State Significant Development Application – SSD 9472

Proposed Sikh Grammar School – 151-161 Tallawong Road, Rouse Hill (Lots 42 & 43 DP 30186)

Table 1: Response Matrix

DRAWING TITLE				
SEDIMENT & EROSION CONTROL PLAN (STAGE 1)				
PROJECT NO.	PLANSET NO.	RELEASE NO.	DRAWING NO.	REVISION
P1806439	PS05	R04	PS05-B300	D

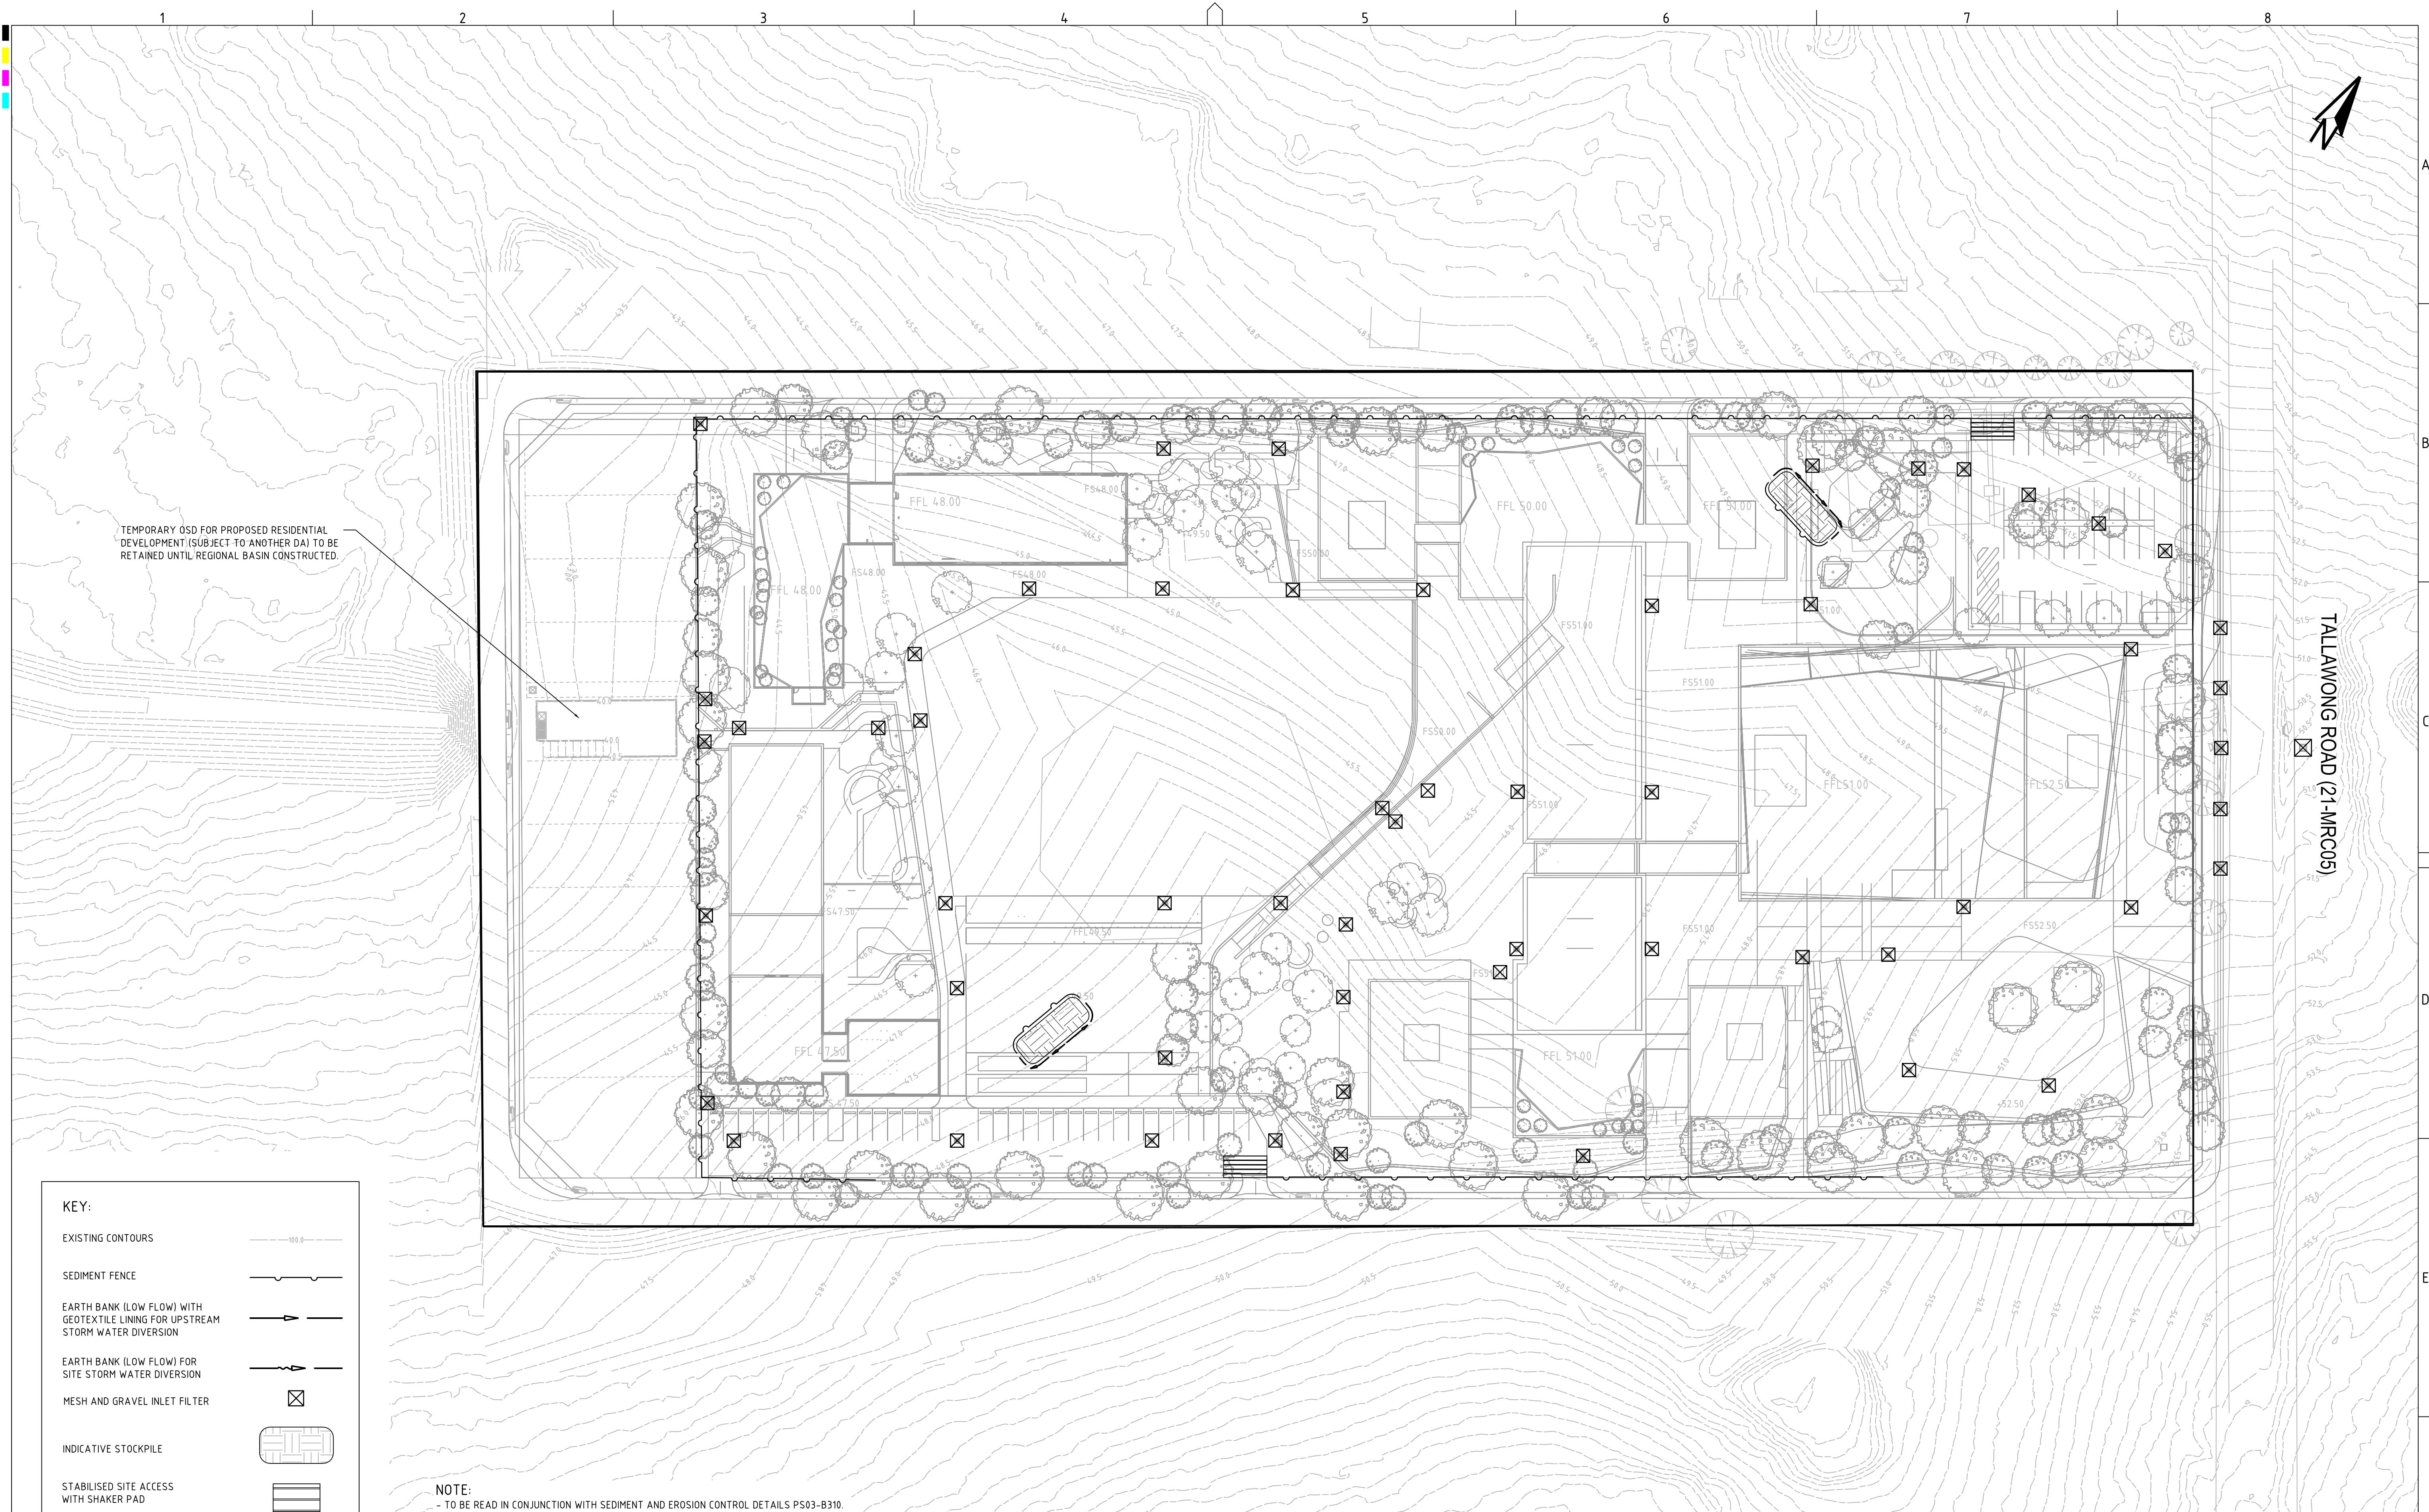
<i>xvii. Temporary OSD is required until the regional basin is operational, to cater for the 1% AEP flows from the site as well as the surrounding roads excluding Tallawong Road.</i>	The half-road construction is subject to a concurrent DA with Blacktown City Council under DA-19-01597 , for which does not form part of the Proposal. Notwithstanding, provisions for OSD have been provided as part of the Proposal. Reference should be made to details articulated within Drawing PS05-E600 and E601 in relation to Stage 1 and the Final Stage (refer to Appendix 11-13).
<i>xviii. Provide an OSD catchment plan for stage 1 showing total catchment area and which area is directed to the OSD system</i>	Reference should be made to Drawing PS05-E600 for the OSD catchment plan in relation to Stage 1 (refer to Appendix 11-13).
